**KIRKLEES METROPOLITAN COUNCIL  
INVESTMENT & REGENERATION SERVICE**

**DELEGATED DECISION FOR DISCHARGE OF CONDITION A.4 -  
NOTIFICATION OF A PROPOSED ENLARGEMENT TO DWELLINGHOUSE**

Reference no.	<b>2018/HH/92804/W</b>
Site Address	<b>30, Marten Drive, Netherton, Huddersfield, HD4 7JX</b>
Description	<b>The proposal is for erection of single storey rear extension. The extension projects 3.7m beyond the rear wall of the original dwellinghouse. The maximum height of the extension is 3.7m, the height of the eaves of the extension is 2.3m</b>
Recommending Officer	<b>Hannah Thickett</b>

PROPOSED
(SAME OVERALL
SIZE AS EXISTING)

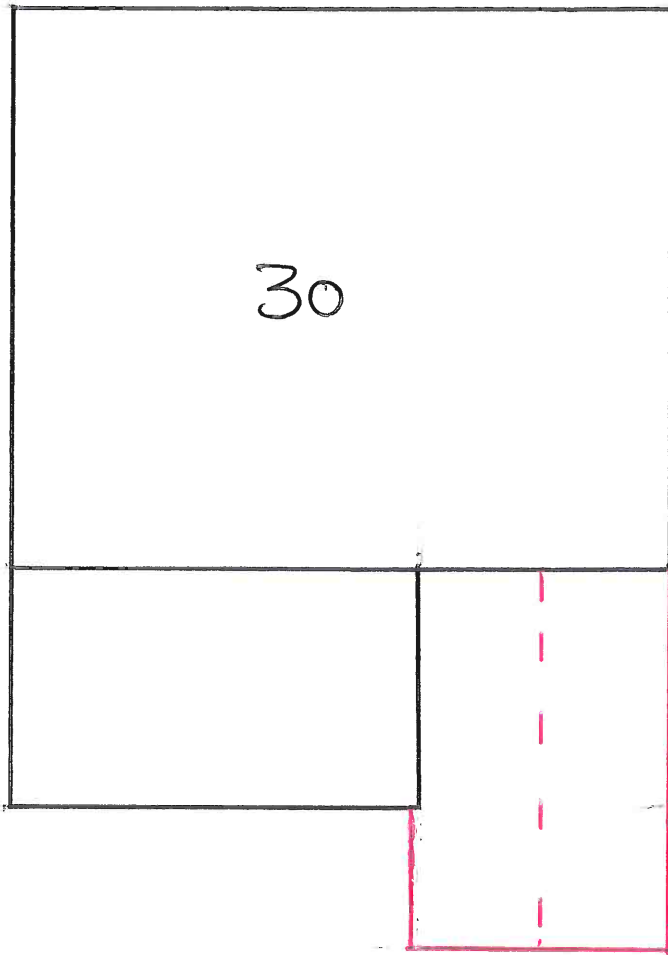
The proposed development would fail to meet the criteria set out under Town and Country Planning (General Permitted Development)(England) Order 2015 (as amended) Schedule 2, Part 1, Class A sub section (j)(iii). Historical imagery shows that the dwelling at 30 Marten Drive, Netherton has an original rear projecting element. Whilst the proposal submitted shows the extension to be half the width of the dwelling, as it is attached to an existing single storey element, the extension has to be considered as a whole. In this instance the proposed extension would fail to meet the requirements as set out in the permitted development order as it extends beyond a side wall forming an original part of the dwelling and is greater than half the width of the original dwellinghouse.
